AB/48/19/PL & AB/49/19/L

Listed building consent for internal and external alterations to facilitate the change of use of upper floors to a single, four bedroomed residential unit [use class C3a] and ground floor to a commercial unit (use classes A1,A2 & B1a).

SITE PLAN

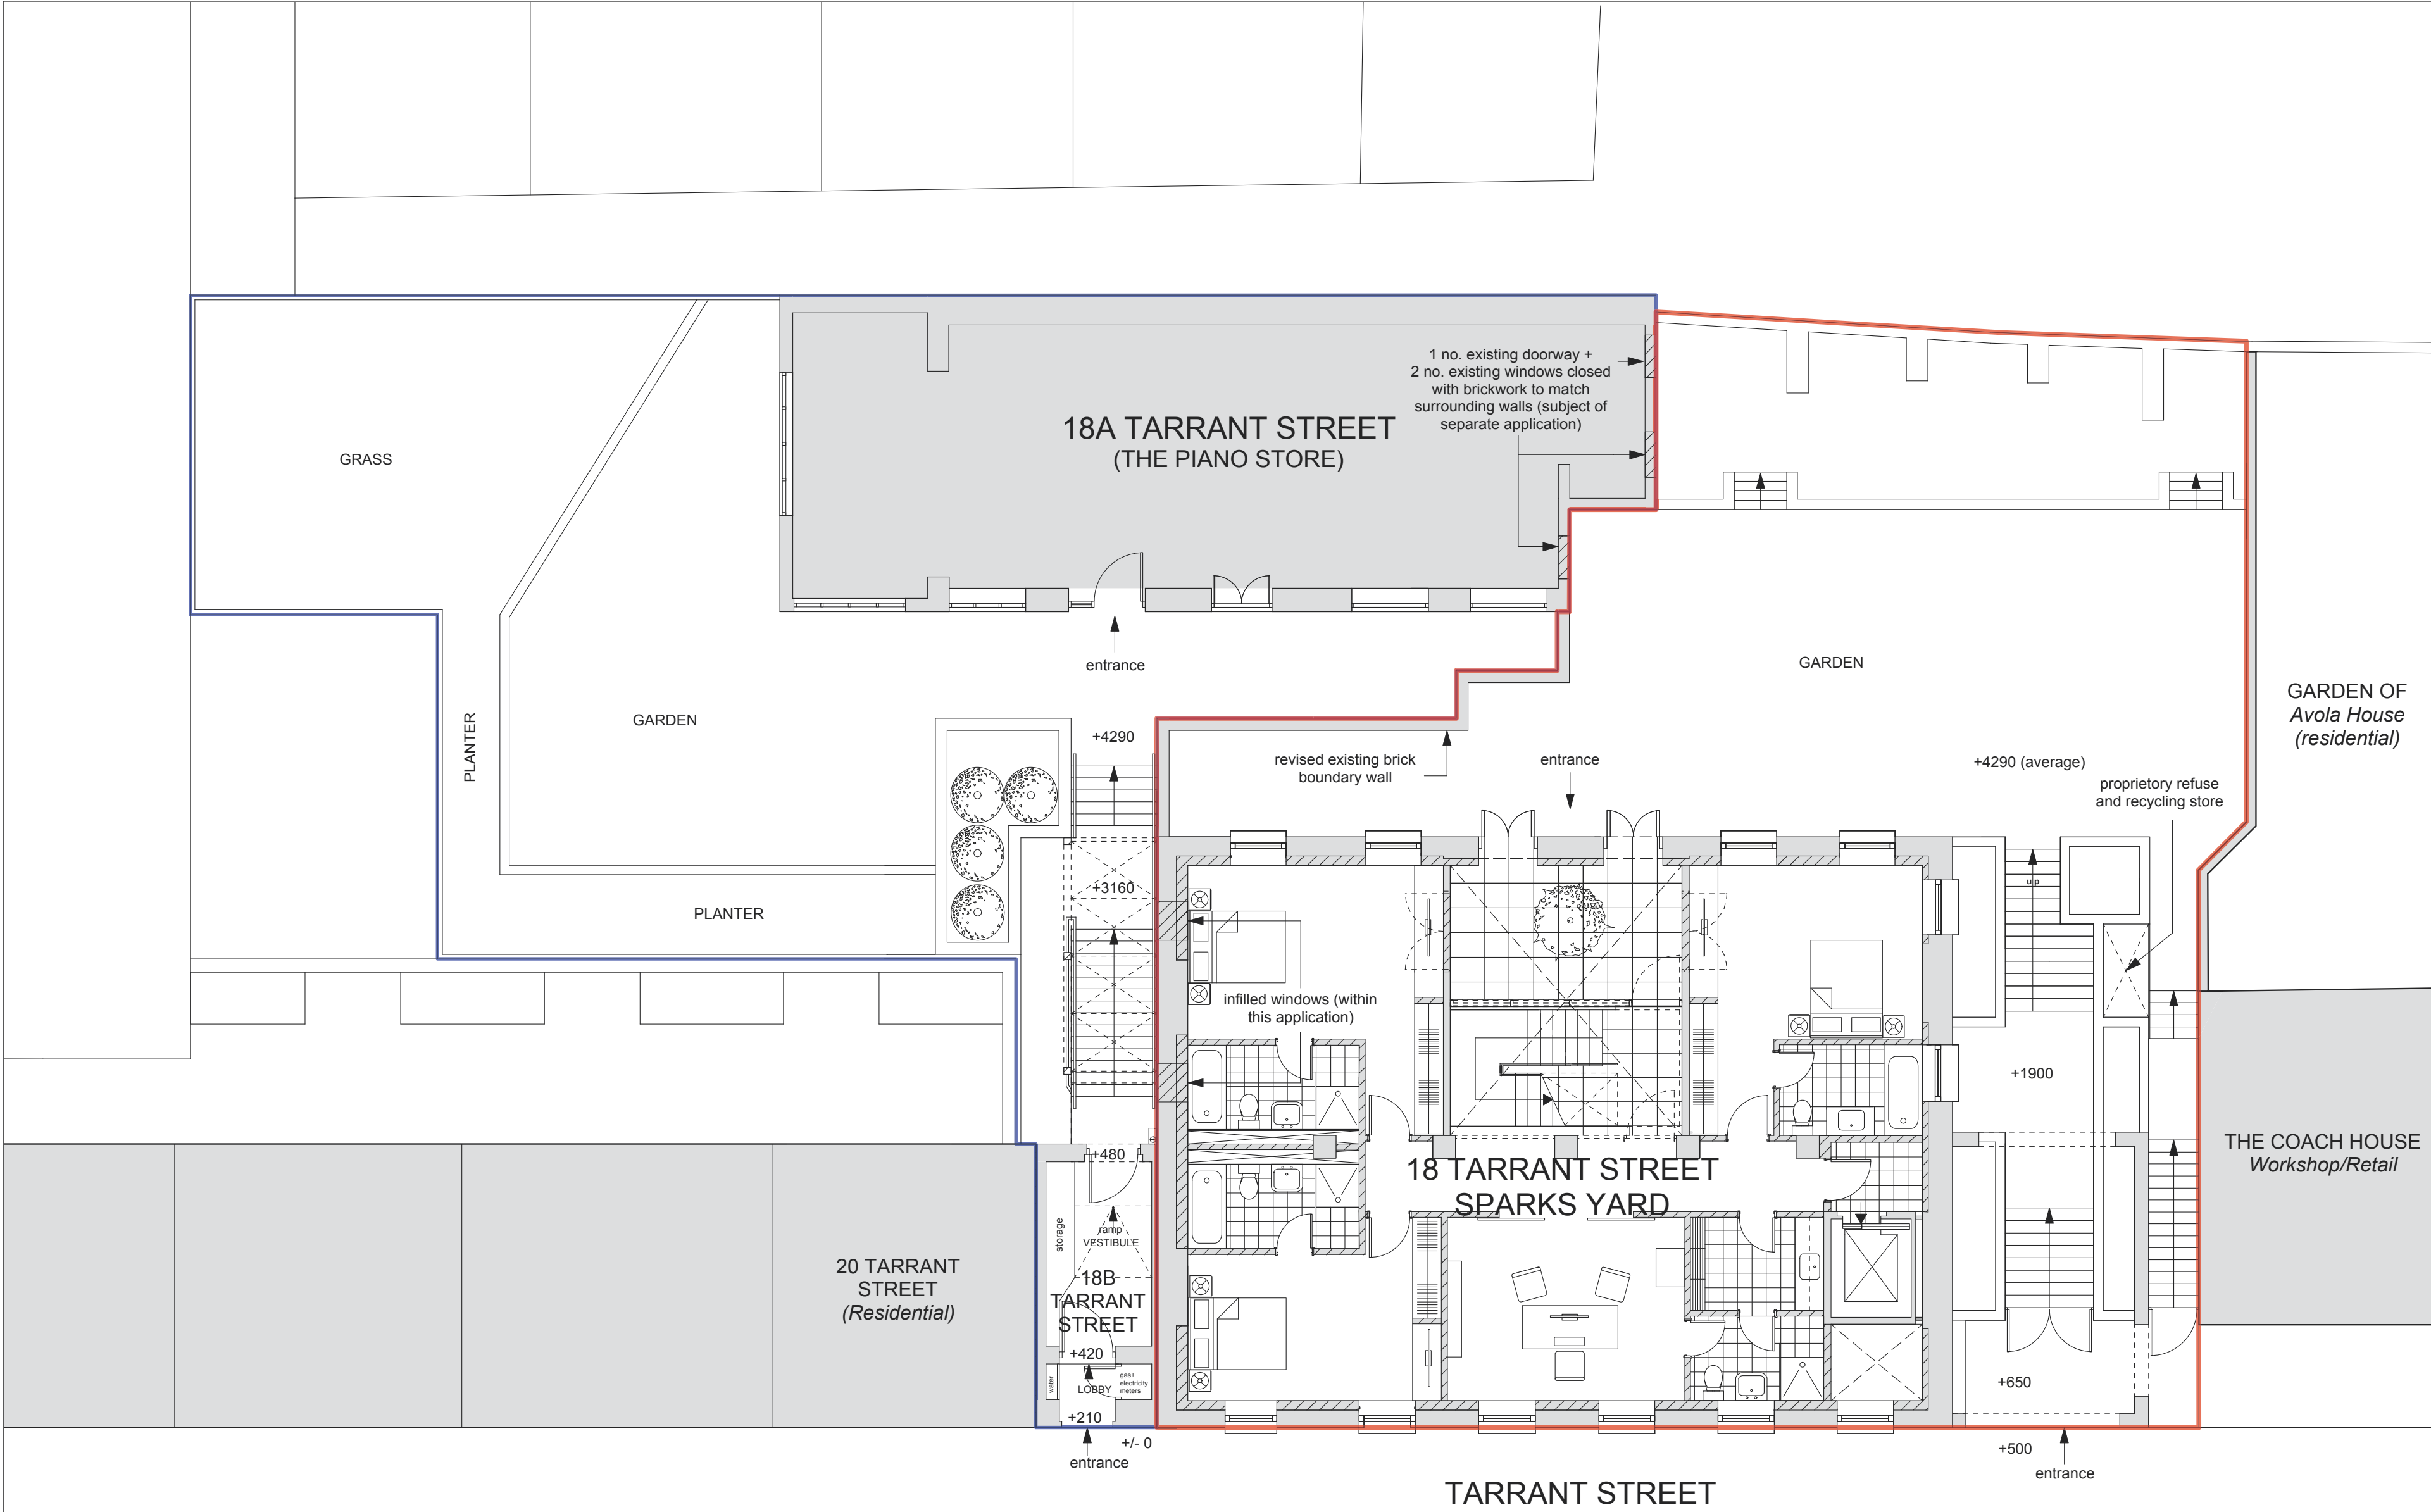
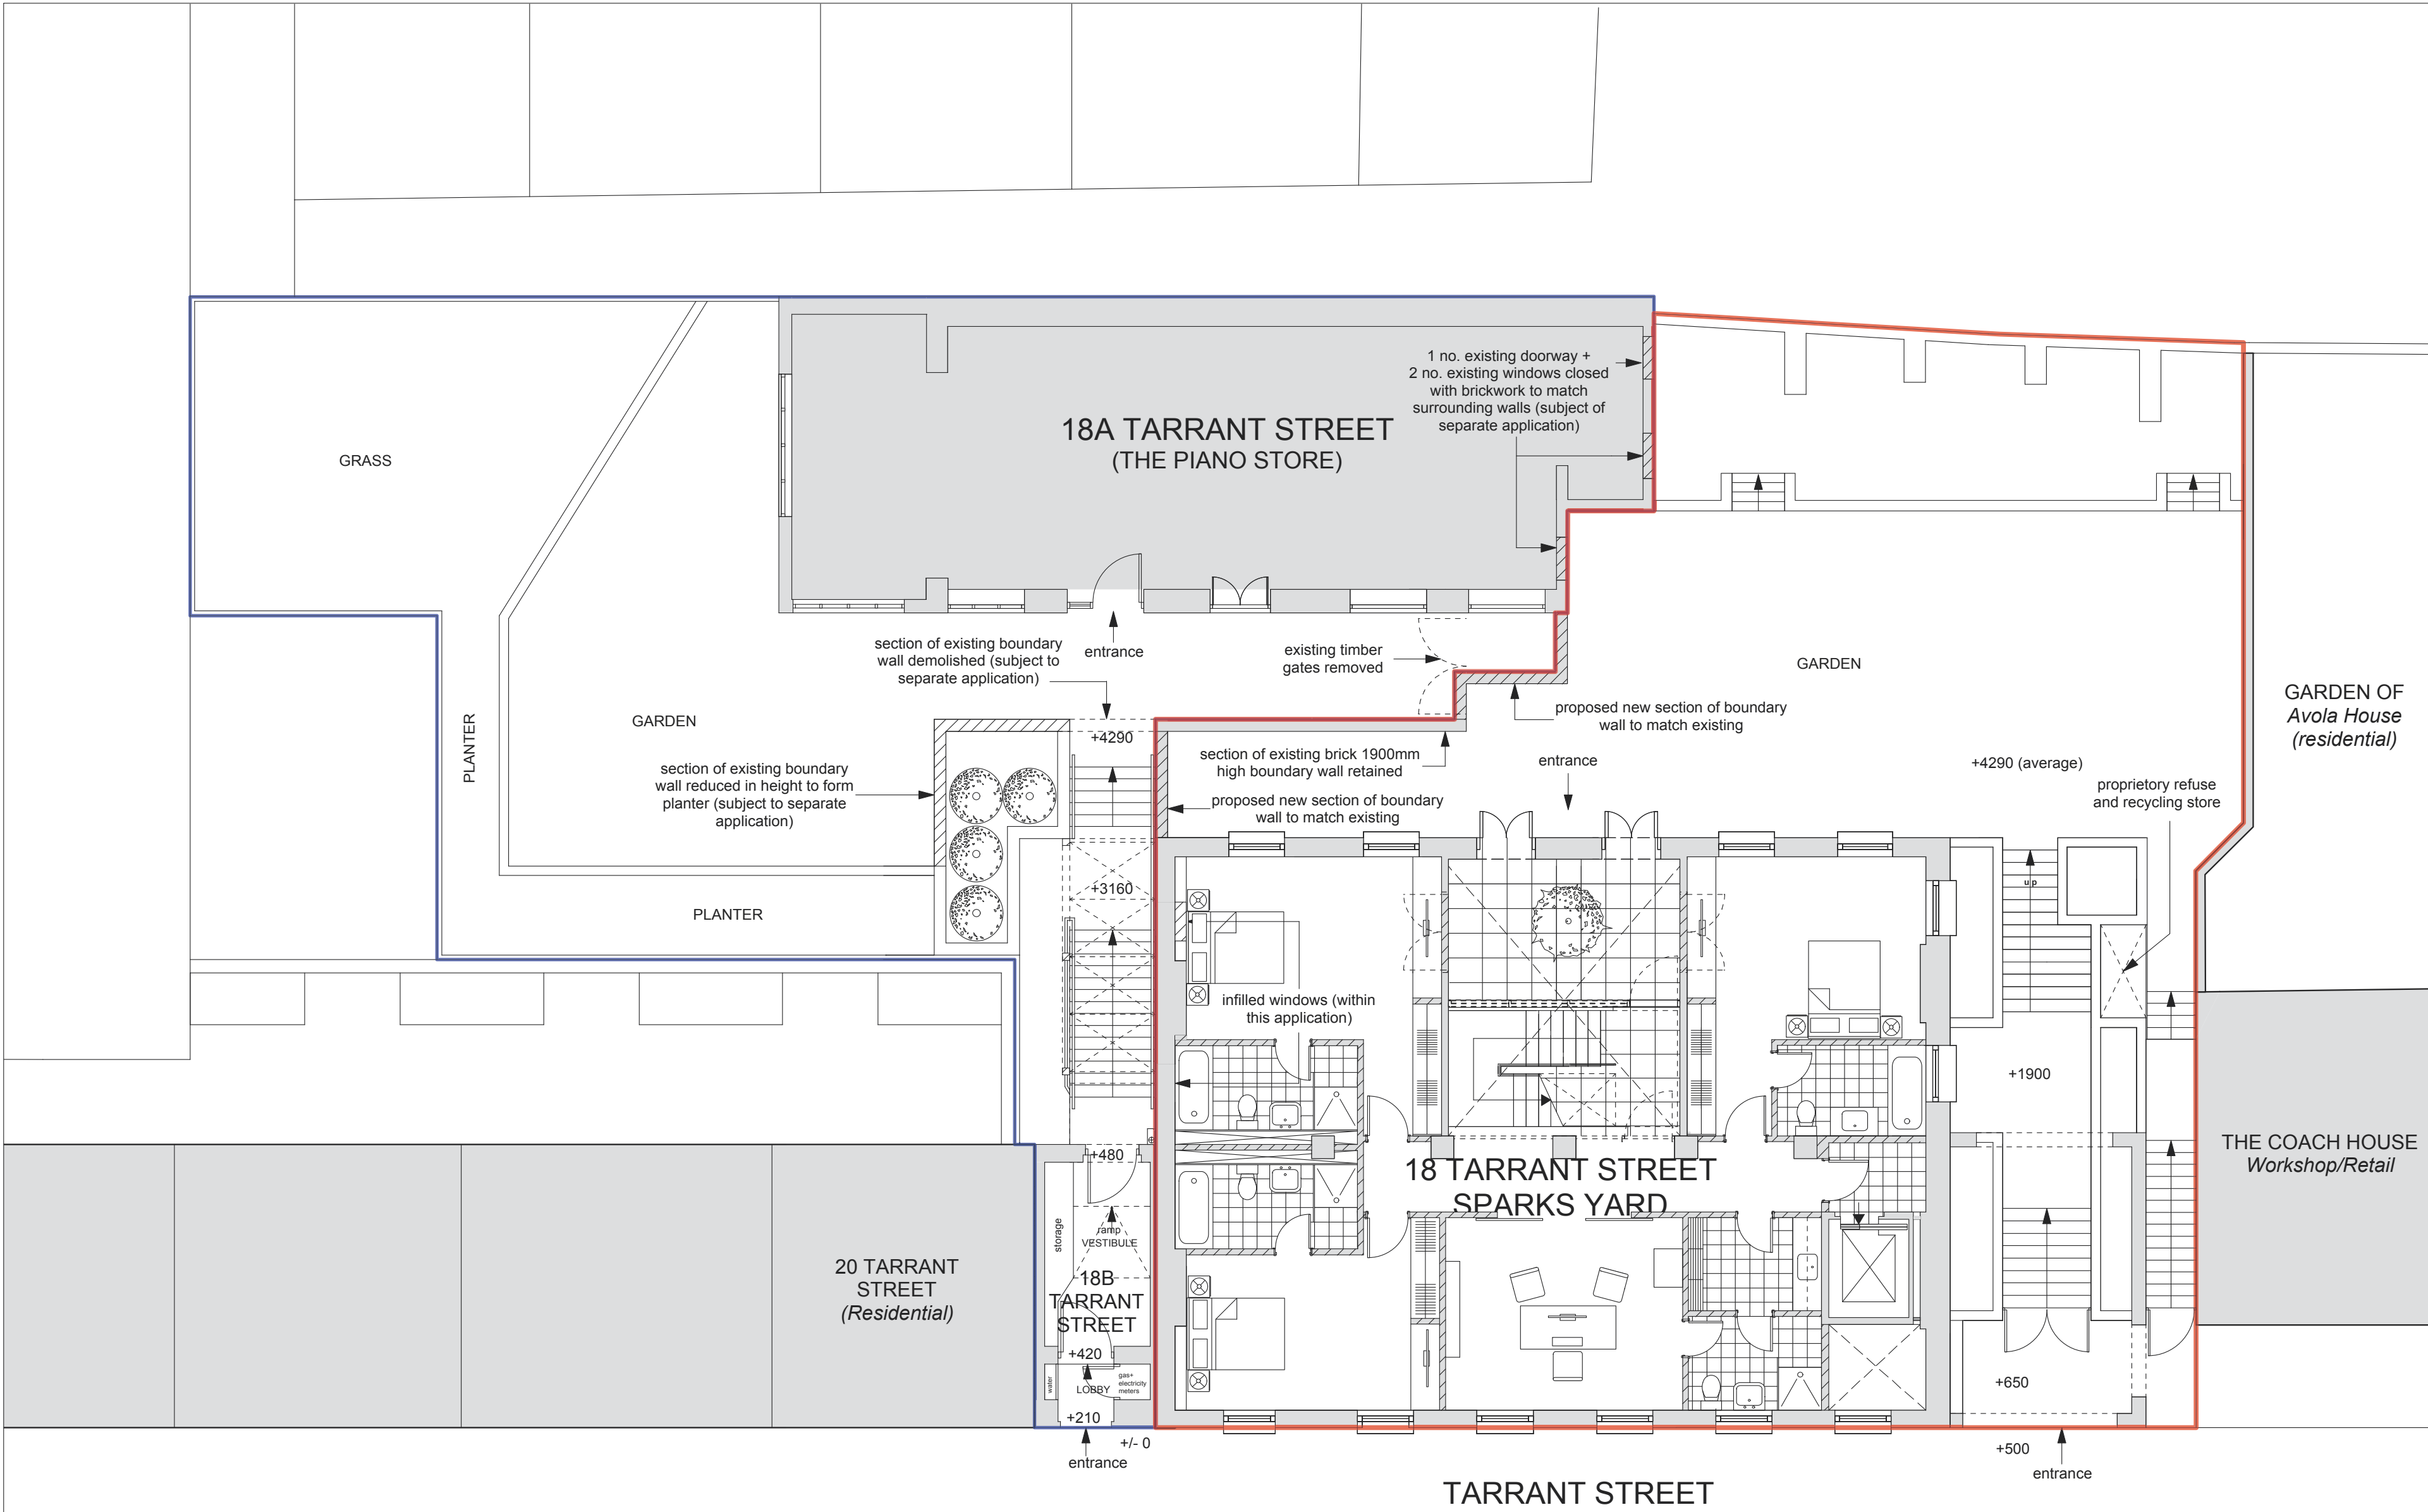
I note from the plans and statements that works will be undertaken to the curtilage wall. However, there is very little information regarding it. Whilst the concept of the wall is generally acceptable, the lack of information makes it hard to fully consider the impact. If minded to approve the application, further details of the wall should be provided.

**PROPOSED WEST
ELEVATION**

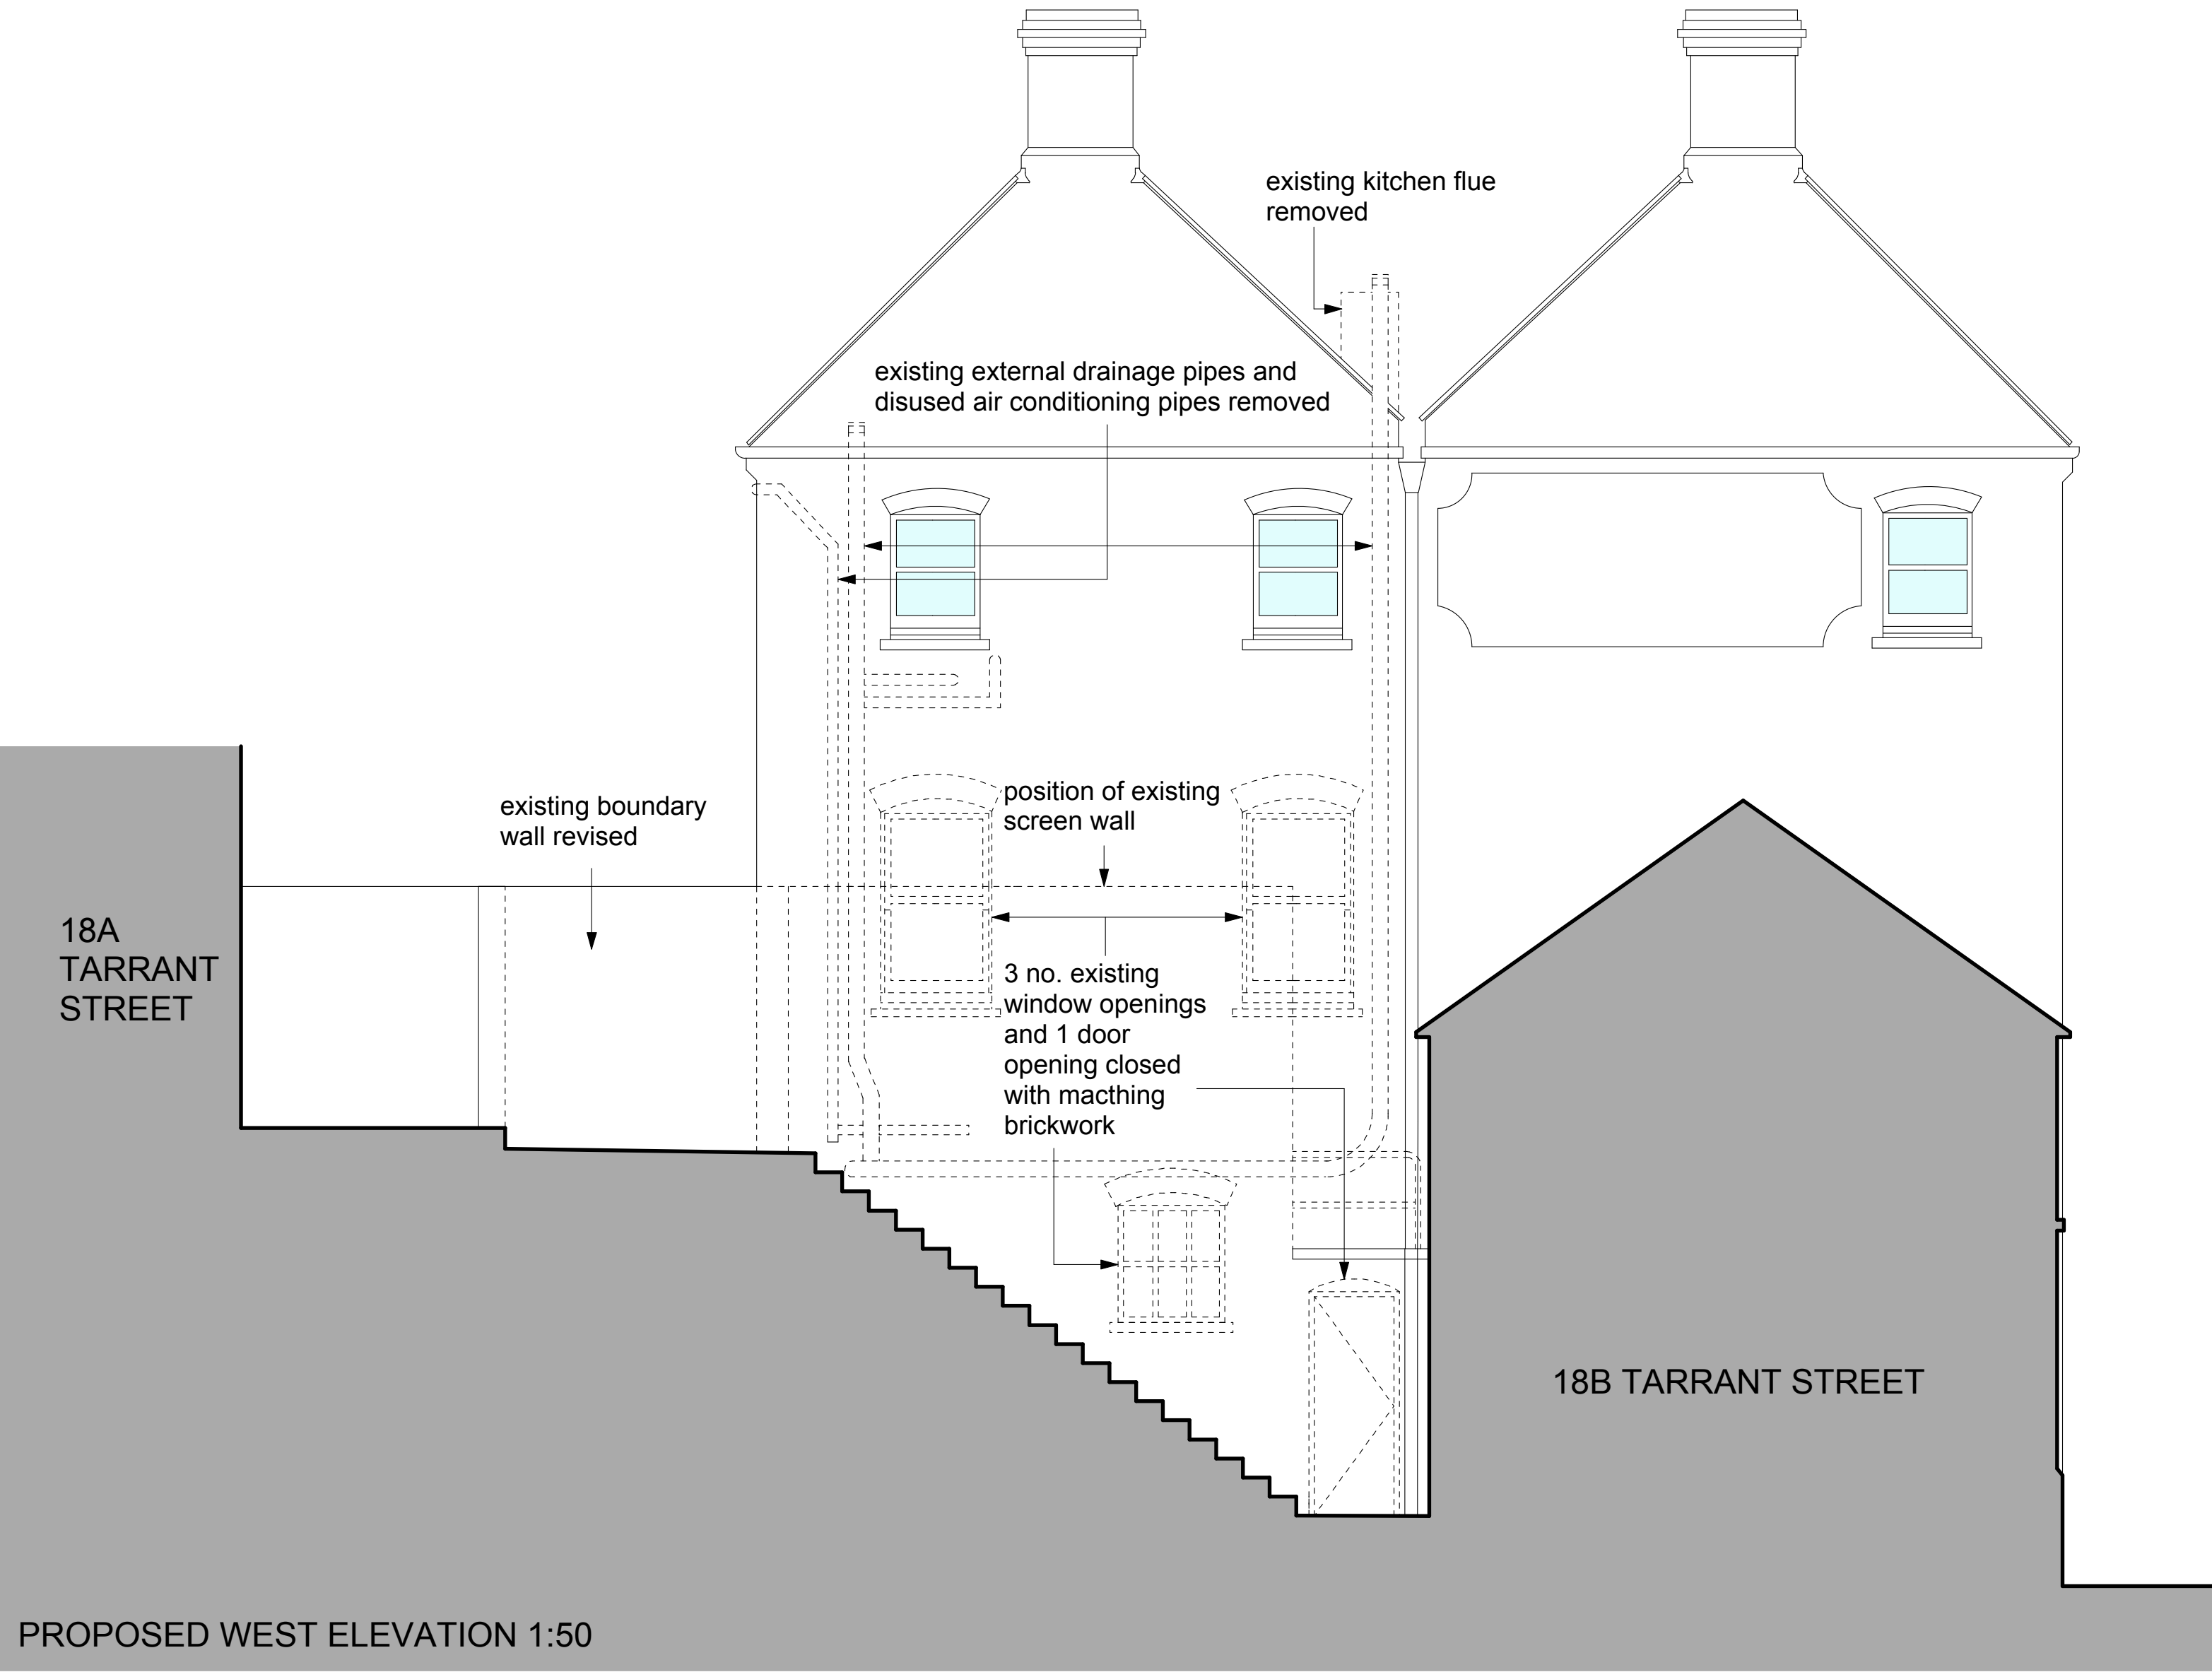
Whilst this is unfortunate, it is acknowledged that the reason behind this is to ensure that a suitable use will be achieved for the property. It is suggested that the proposed brickwork which would be used to infill the windows/door should be slightly recessed so that the former openings can be read and understood as a development of the building. All brickwork and mortar should match the existing in terms of appearance and bond. It is suggested that the bricks removed in order to create a new opening for the lift motor room could potentially be used for this purpose, if considered to be suitable/match those used in the elevation.

The removal of all extraneous drainage pipework from the western elevation will have a positive impact upon the appearance of the building.
